Ribble Valley Borough Council

DELEGATED ITEM FILE REPORT - APPROVAL

Application No:	3/2012/0254/P (LBC) & 0255 (PA)
Development Proposed:	Conversion of barn into one dwelling at Chadwicks Farm, Settle Road, Bolton-by-Bowland

drawing:
Proposed Plans, Section and Elevations

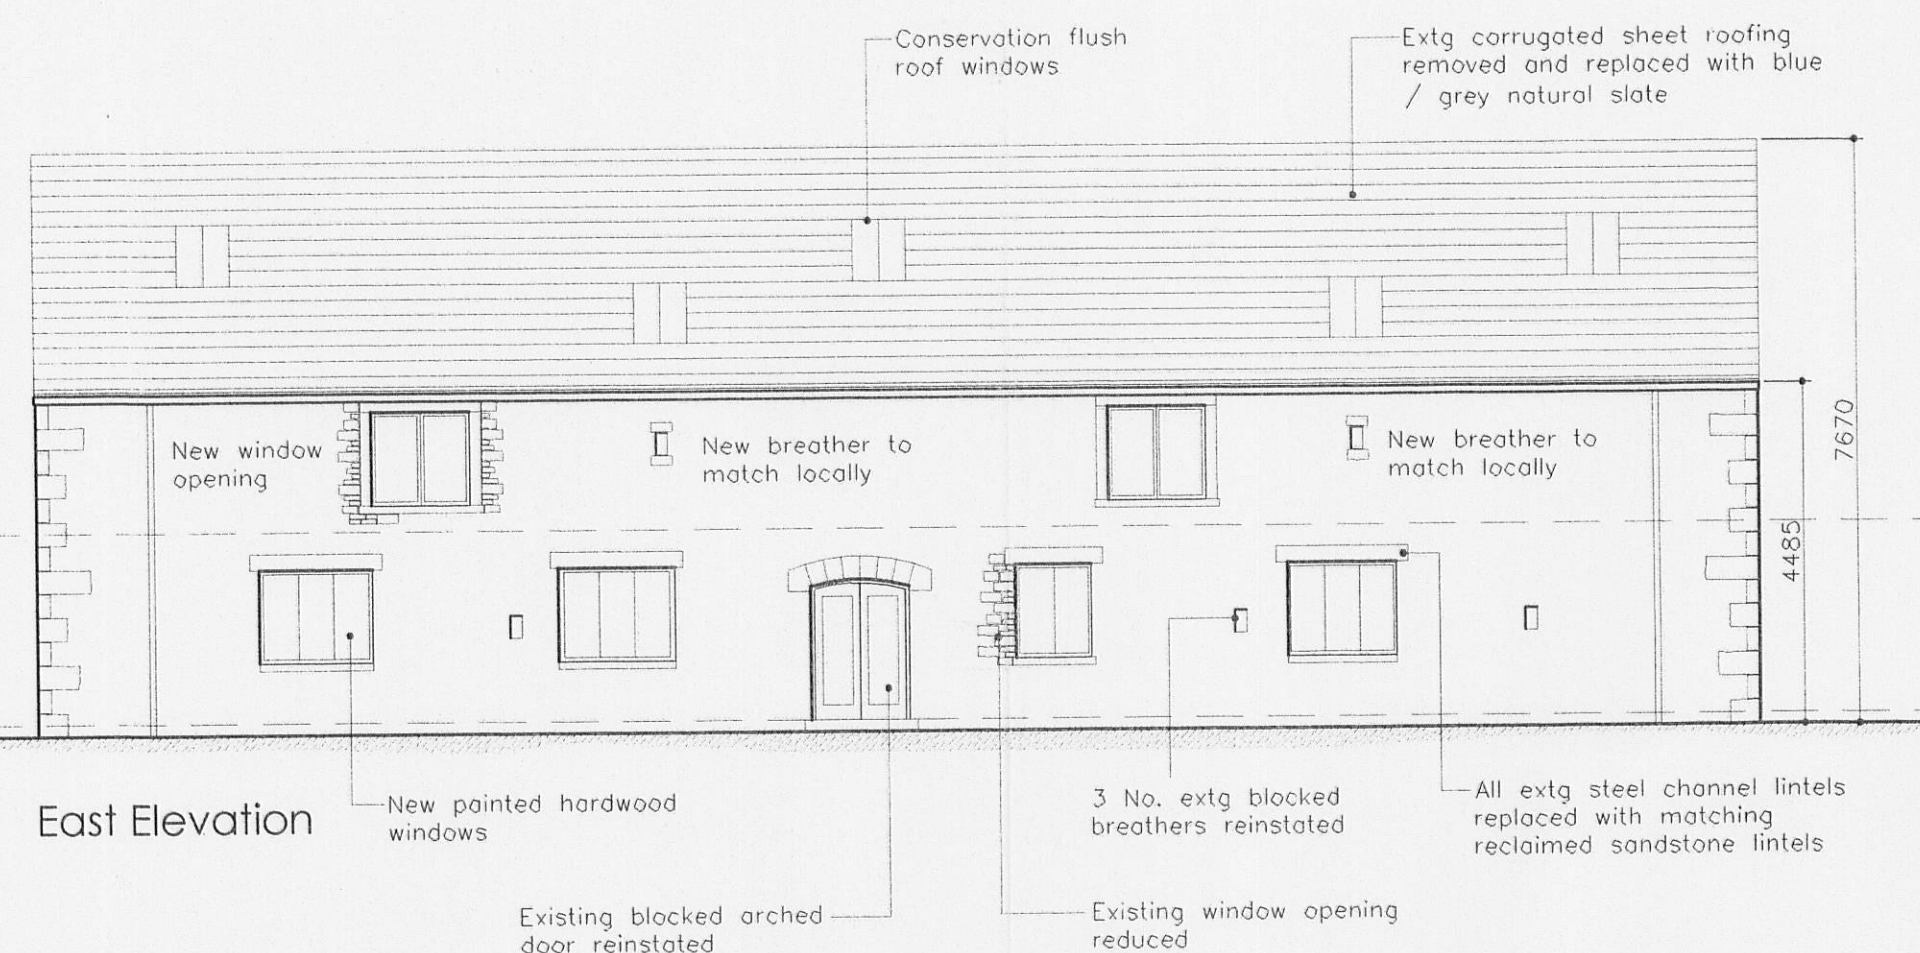
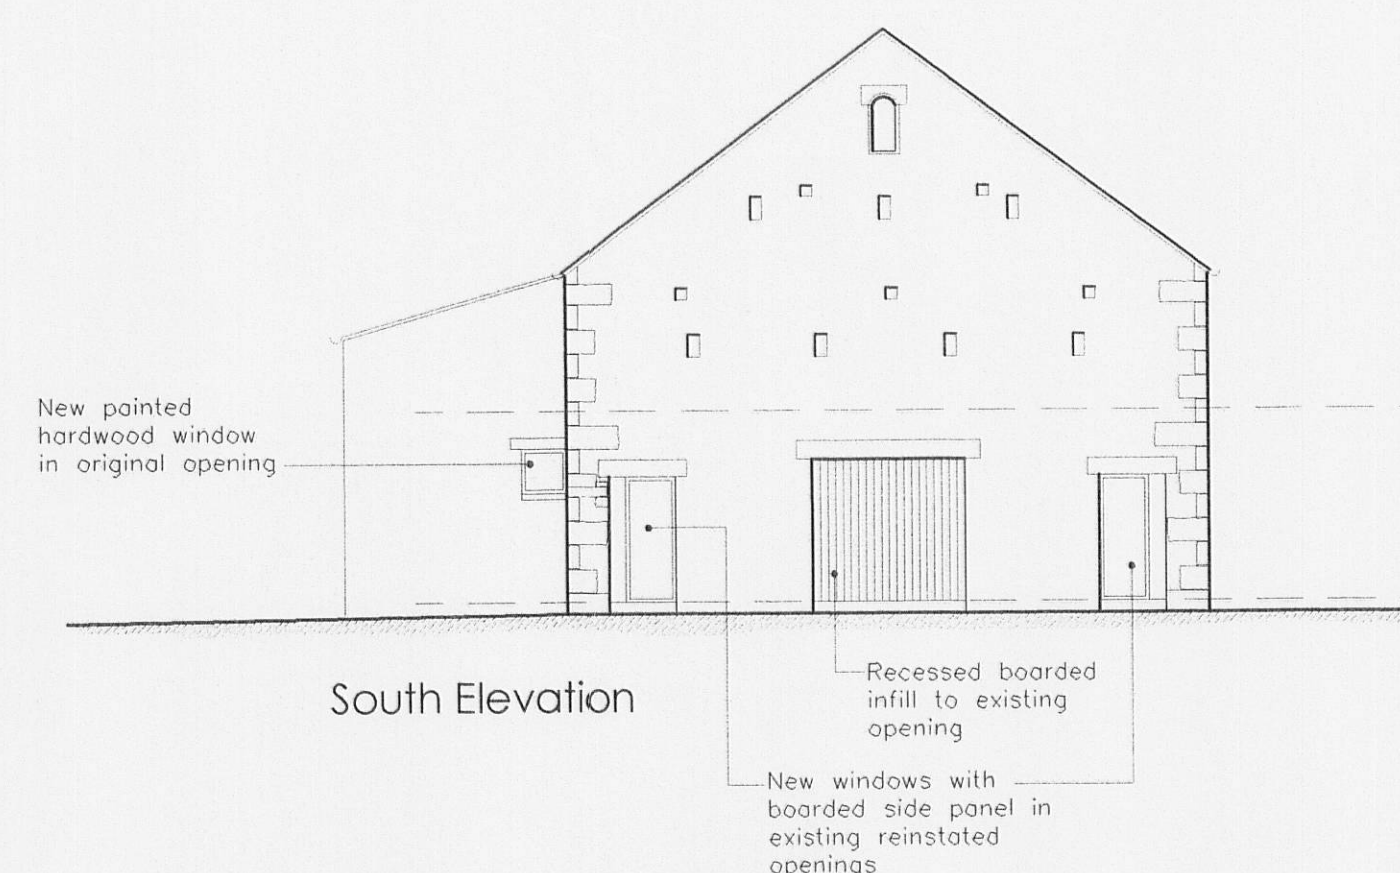
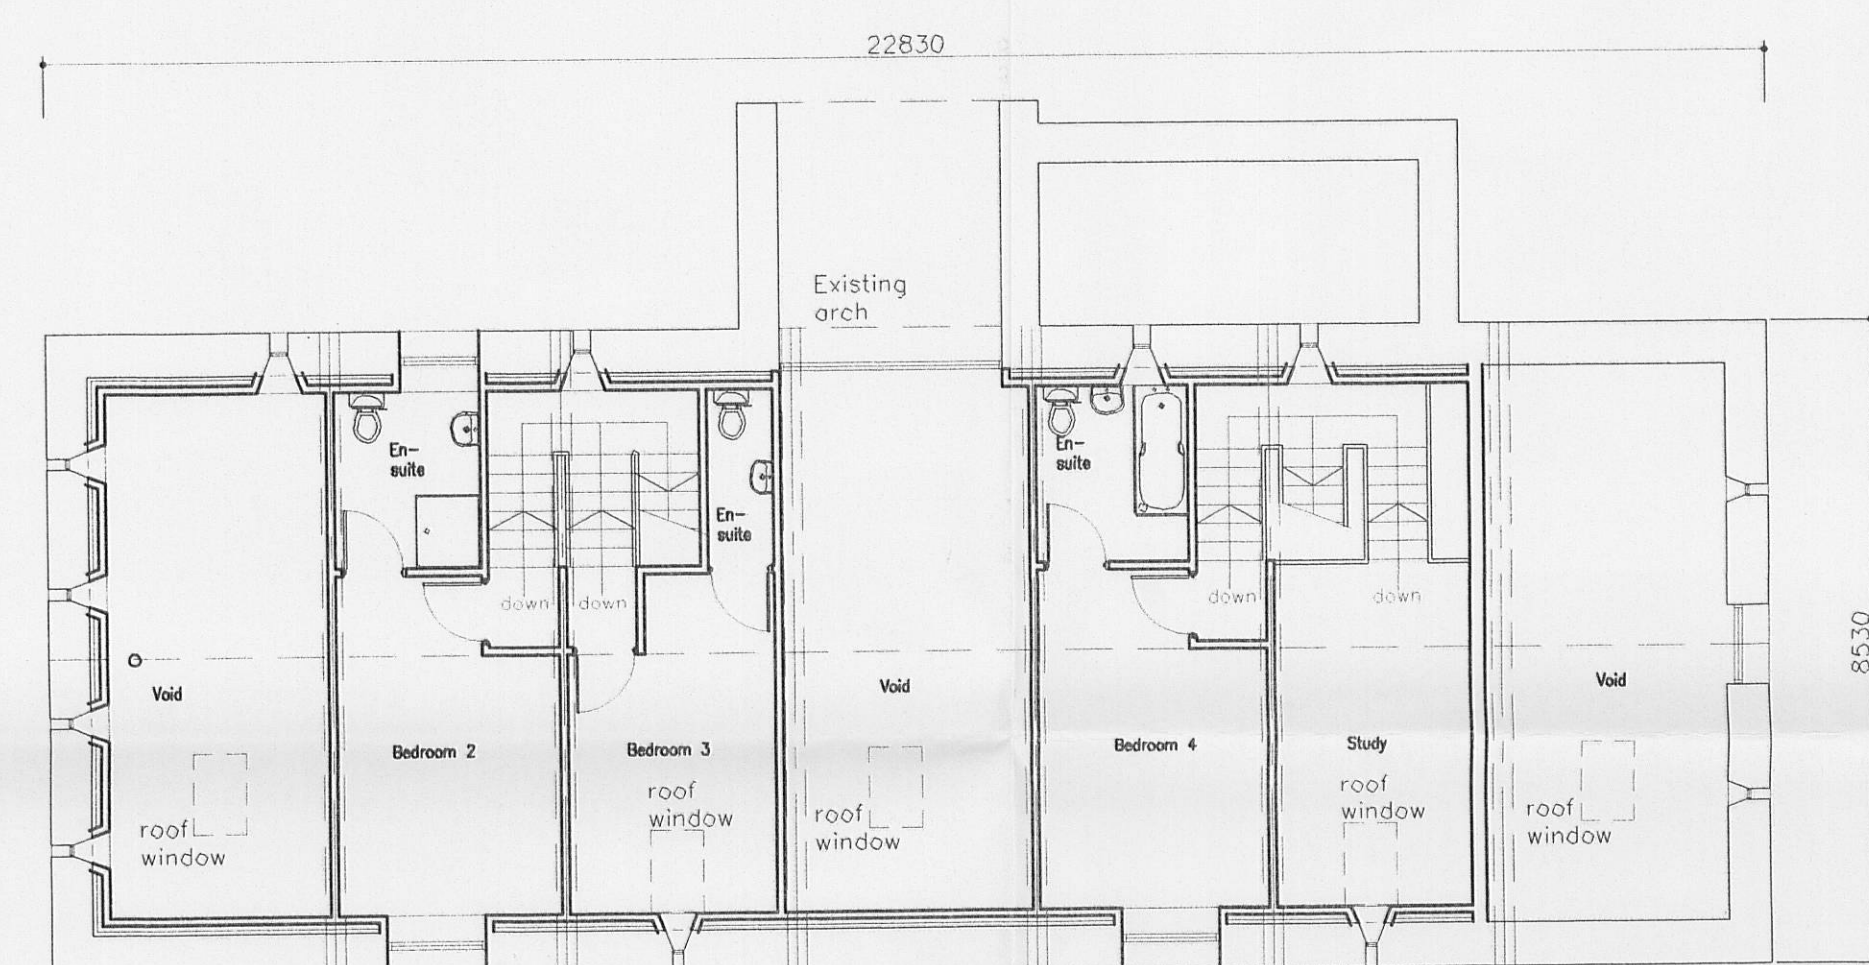
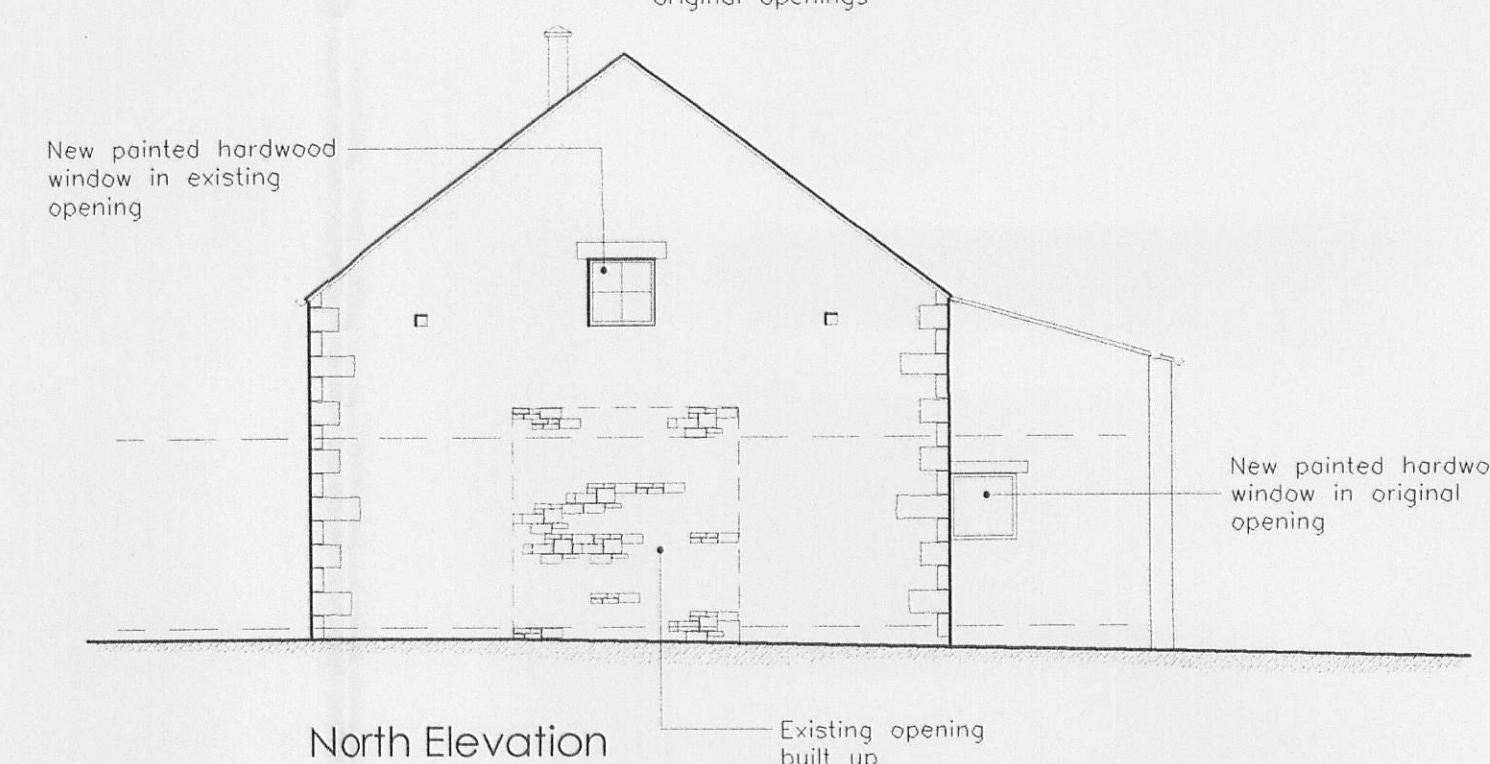
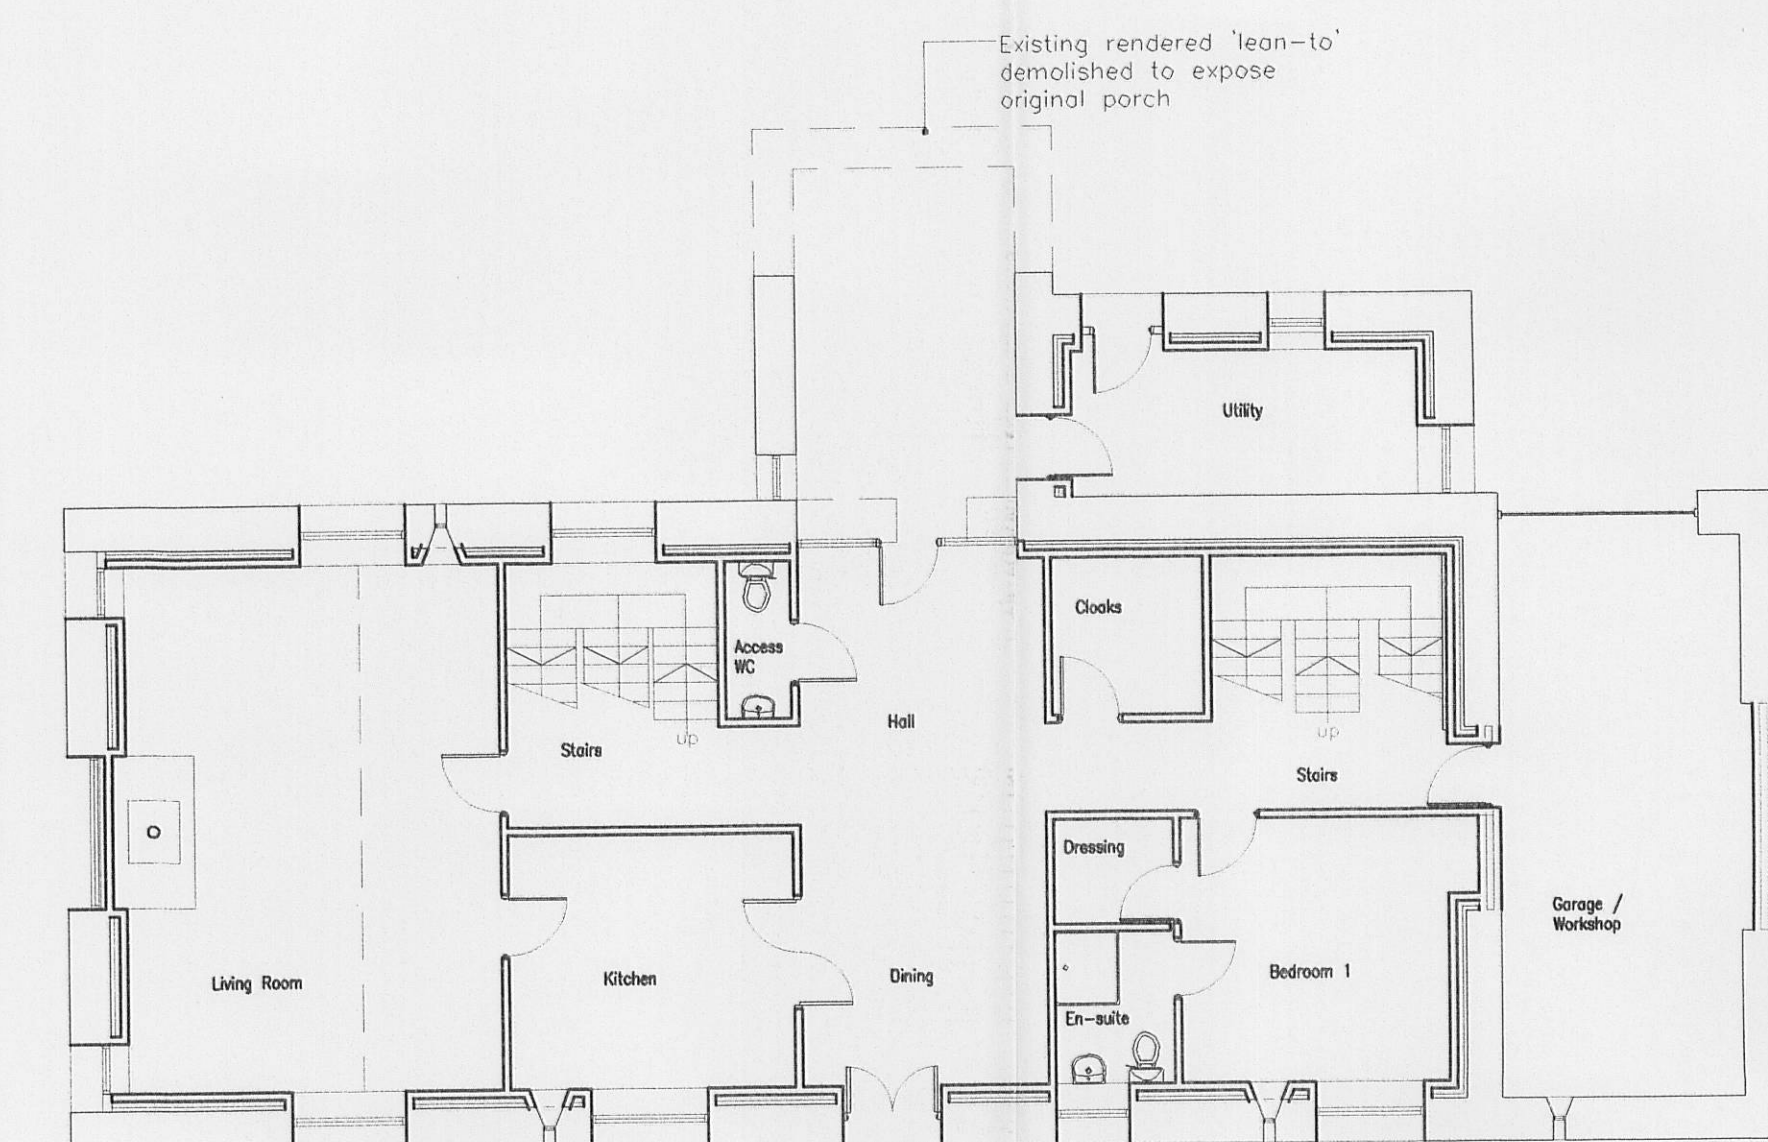
In my opinion, the scheme now proposed is based upon a thorough understanding of the significance of the historic agricultural building and is acceptable. The scheme includes enhancements to the significance including exposure of the original c.1700 cart door and porch and restoration of the full-height threshing bay. Whilst there are also losses to the significance including removal of important evidence for the changing historic usage of the barn e.g. unblocking of the second cart door (possibly original and with two historic layers of change), these adverse impacts can be minimised by the imposition of conditions i.e. deleting unnecessary roof lights from the three full-height bays and reducing the size of the new window to Bedroom 2.

The proposal, subject to amendment by condition, has an acceptable impact upon the character (including setting) and significance of the listed building and heritage asset, the landscape and character of the Forest of Bowland Area of Outstanding Natural Beauty, residential amenity and highway safety. It is acceptable residential development in the open countryside. This is in accordance with Policies ENV20, ENV19, ENV1, G1, H2, H15, H16 and H17 of the Ribble Valley Districtwide Local Plan.
